21 December 2021

**St Aloysius College - Rozelle Campus (SSD-27208140)
Response to Submissions**

Attachment A

Figure 2 Landscape drawing showing basketball courts and nearest residents

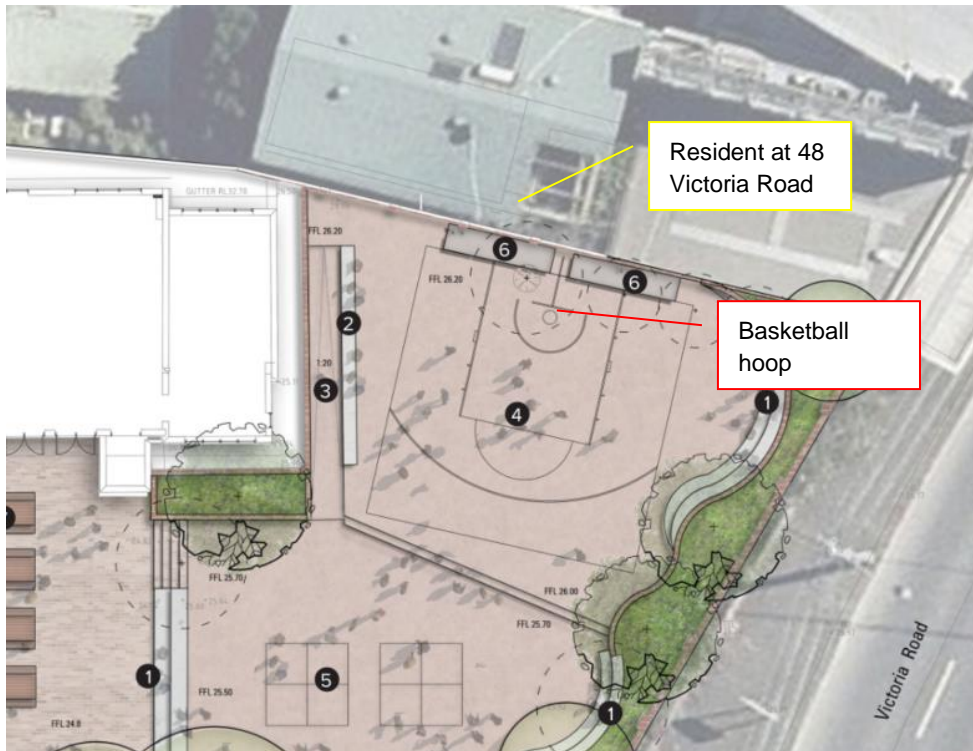
- The site at 48 Victoria Road adjoins a busy road. However, the submitted Acoustics Report does not predict the acceptable noise level for the students using the outdoor play on this site adjoining the busy road. You should amend the Acoustic Report to assess the adverse impacts that students will experience in this open space as a result of the traffic noise along Victoria Road. Should the report conclude that the impacts are unacceptable, then additional noise mitigation measures and barriers may be required and must be outlined in the response to submissions.

48 Victoria Rd-Proposed Plan L1 St Aloysius College-Rozelle Campus

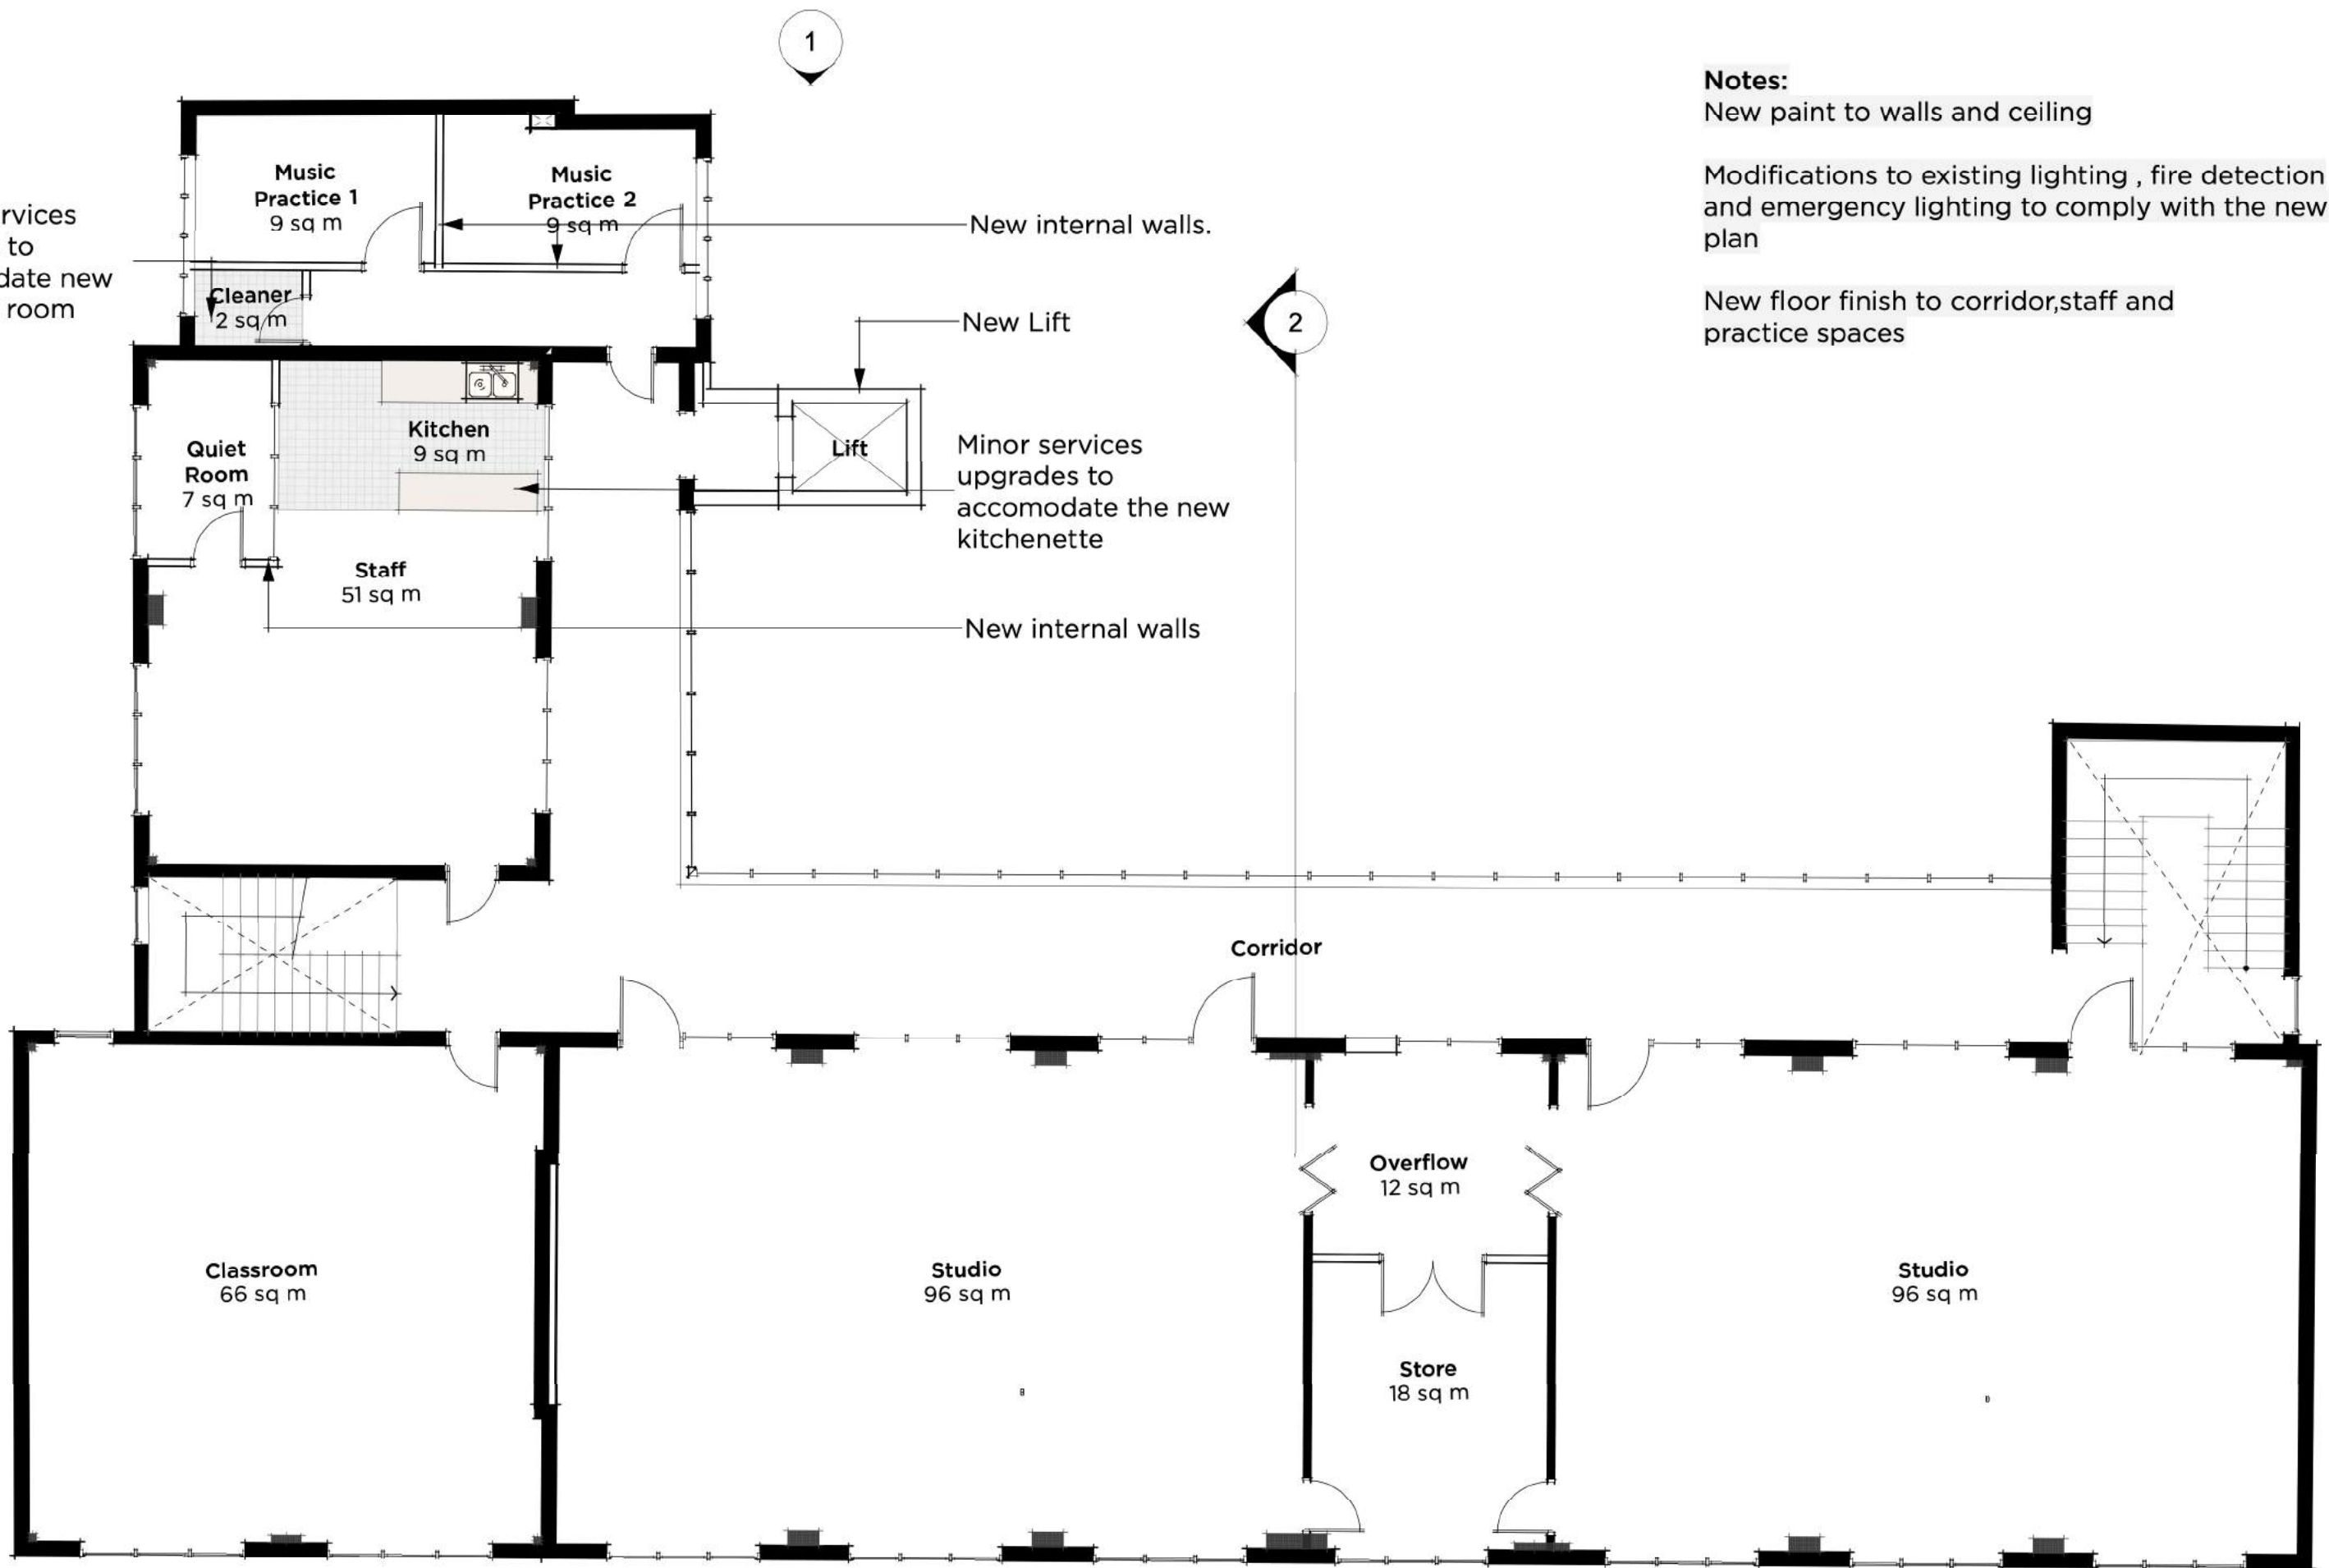
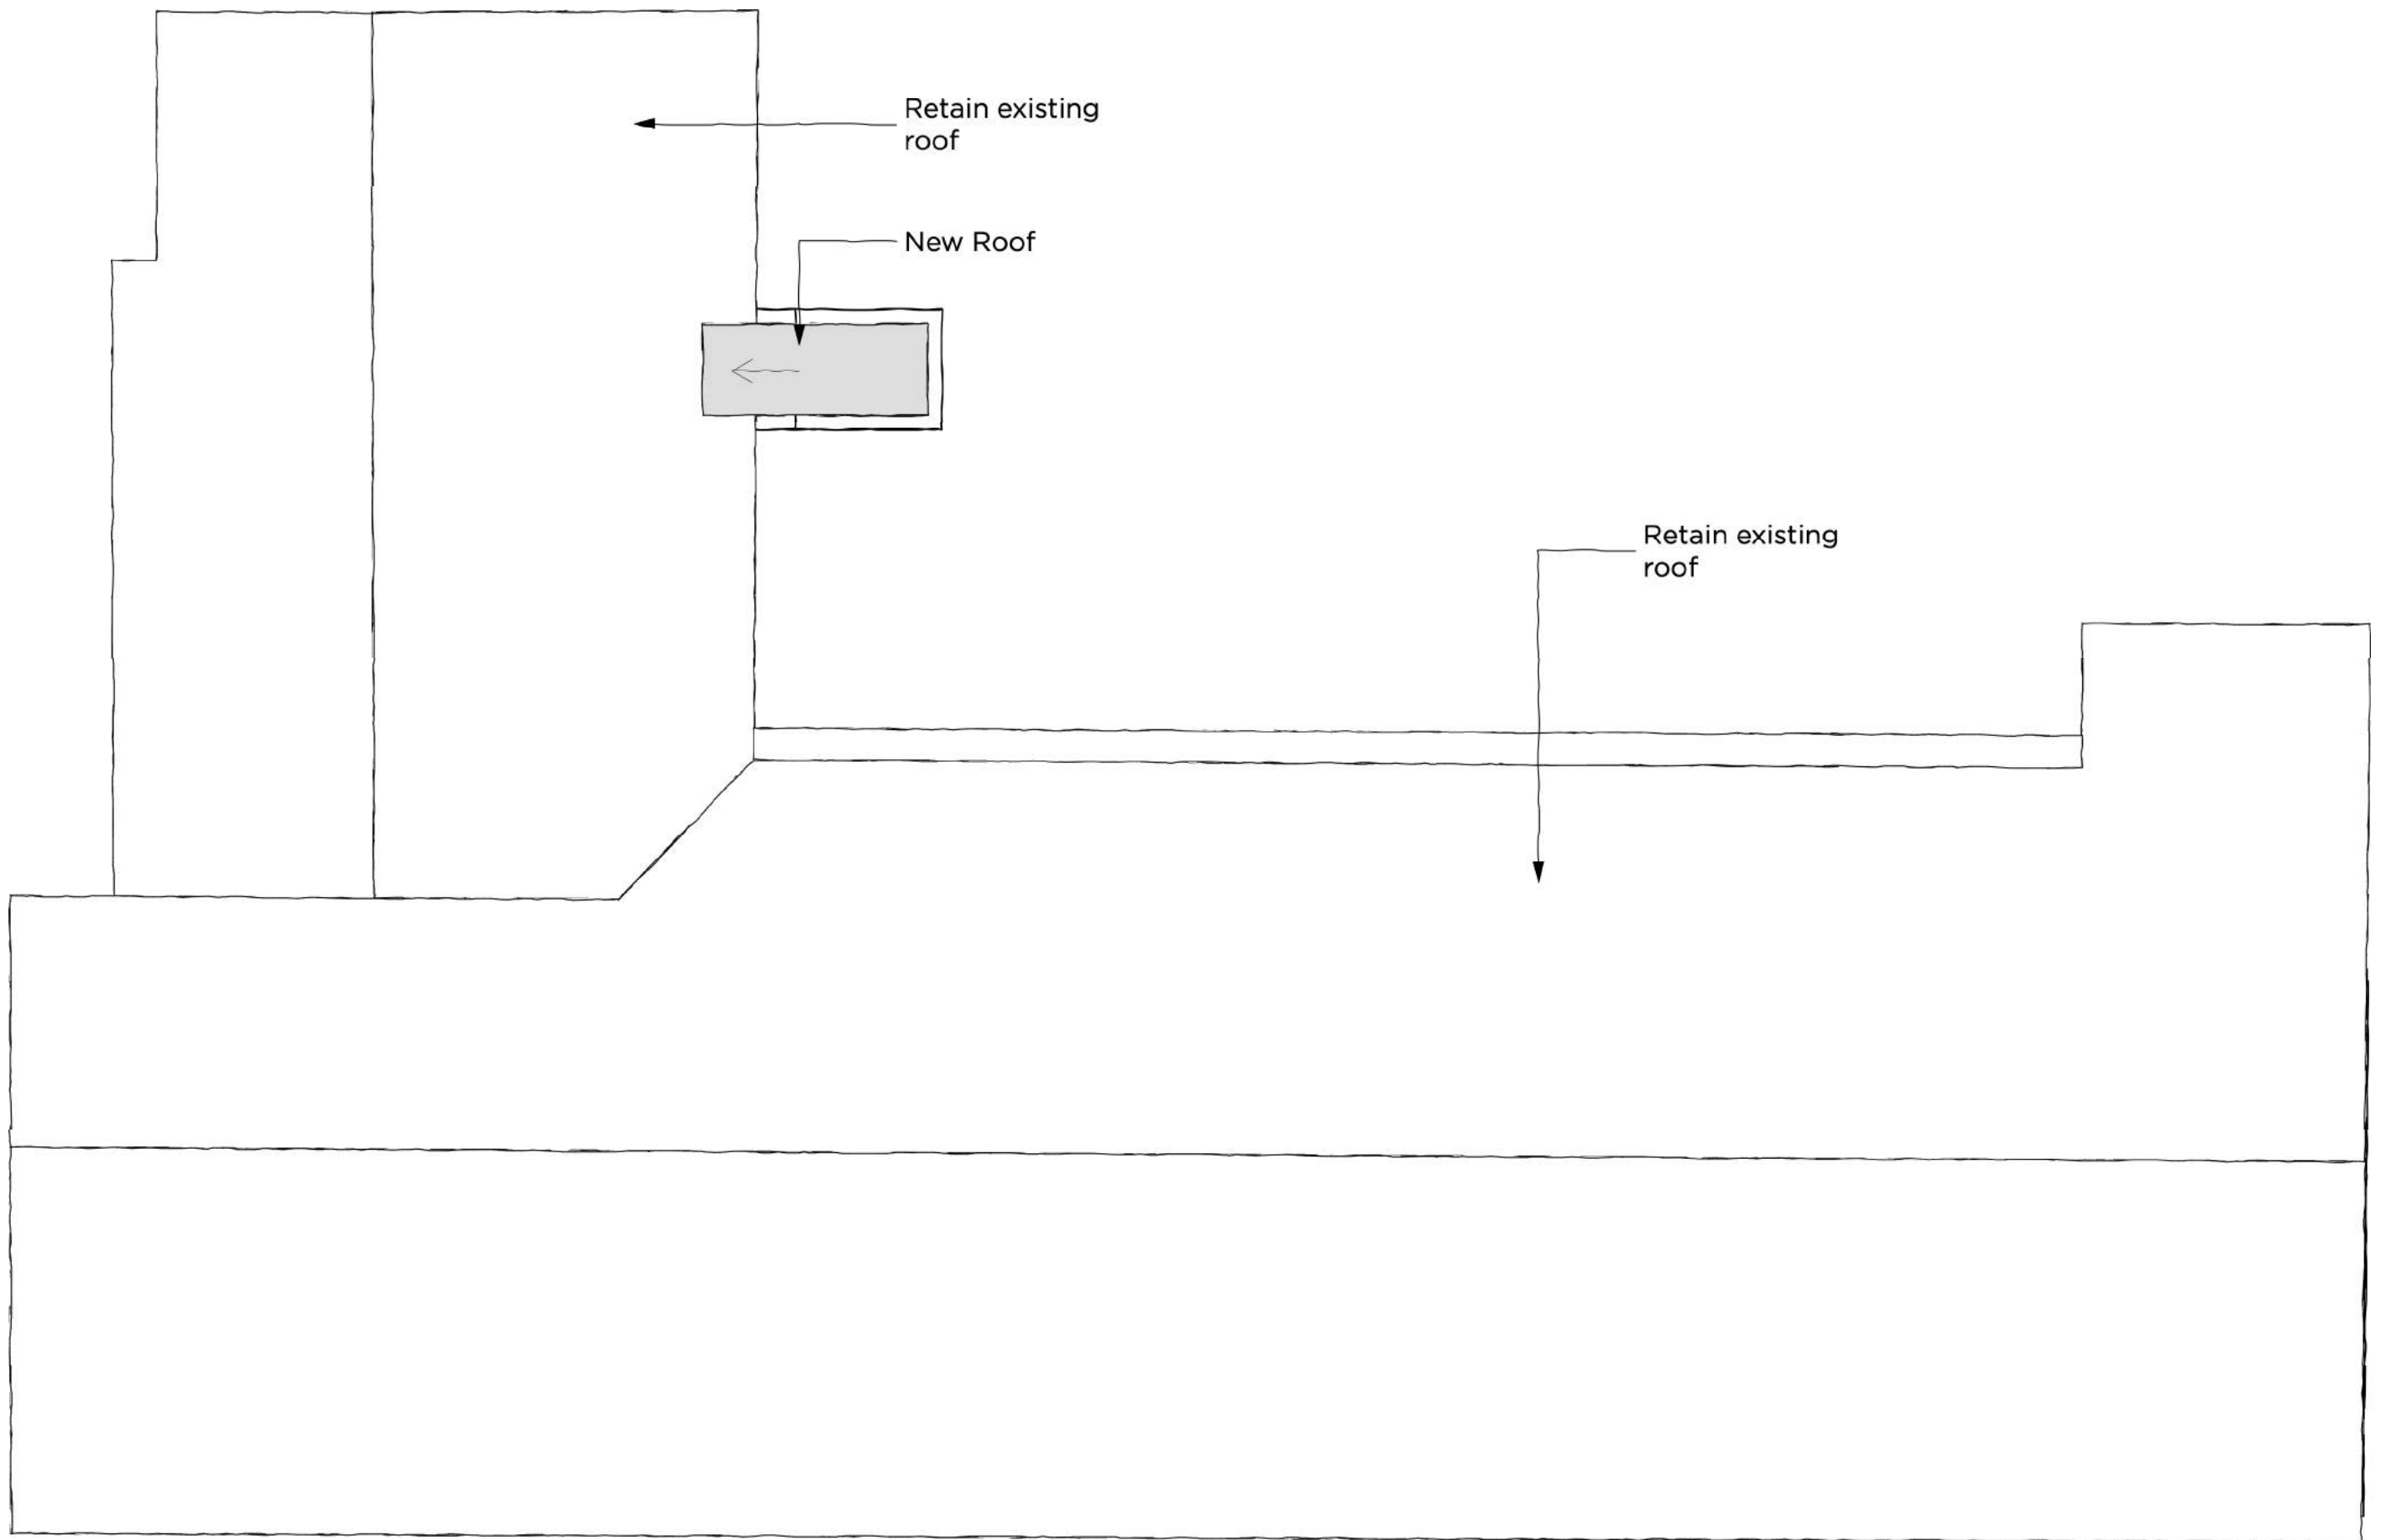
- Level 1 of the site at 2B Gordon street has been identified as class 5 building in the submitted BCA assessment. The Access report considers the use to be for office purposes and staff room. However, according to the EIS and architectural plans, Level 1 of 2B Gordon street would be used as classrooms. Noting this significant discrepancy, the Department requires to you submit an amended BCA Assessment and Access Report to be consistent with the EIS.
- A detailed assessment of the proposal against all relevant deemed to-satisfy provisions of the BCA has been provided within Annexure D of BCA Assessment report. As the proposal is located on two separate sites, you are requested to provide two separate assessments for each building in an amended BCA Assessment report.

Figure 11: On-Street Parking Survey Summary (2022)

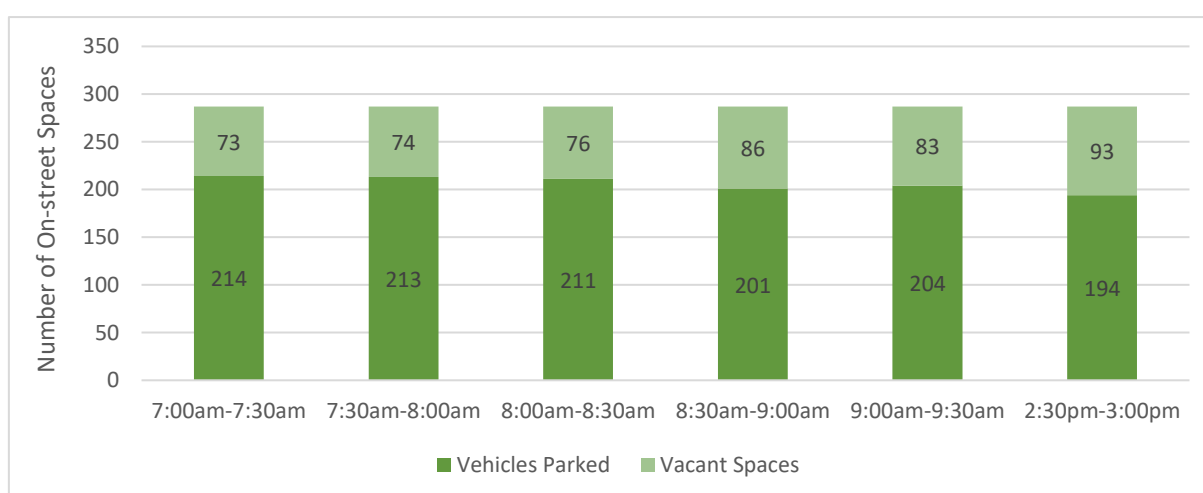
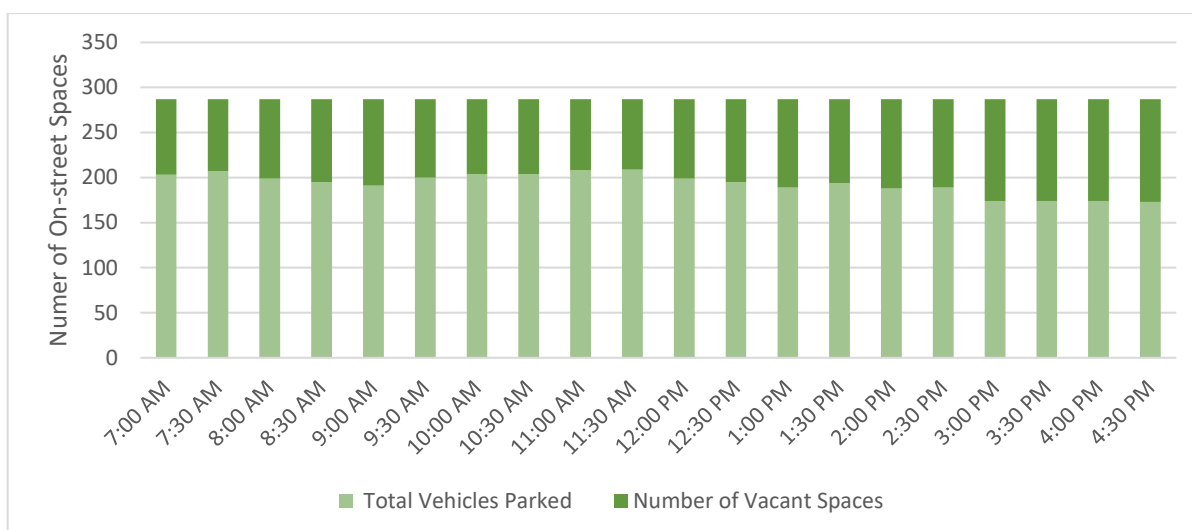
- Additionally, the Department notes that the traffic and on-street parking surveys were conducted during COVID-19 lockdown period on 7 October 2021. Therefore, the results may not reflect the usual amount of traffic and available on-street parking. The Department considers that the traffic surveys should be re-conducted due to this reason and the TAIA amended accordingly.
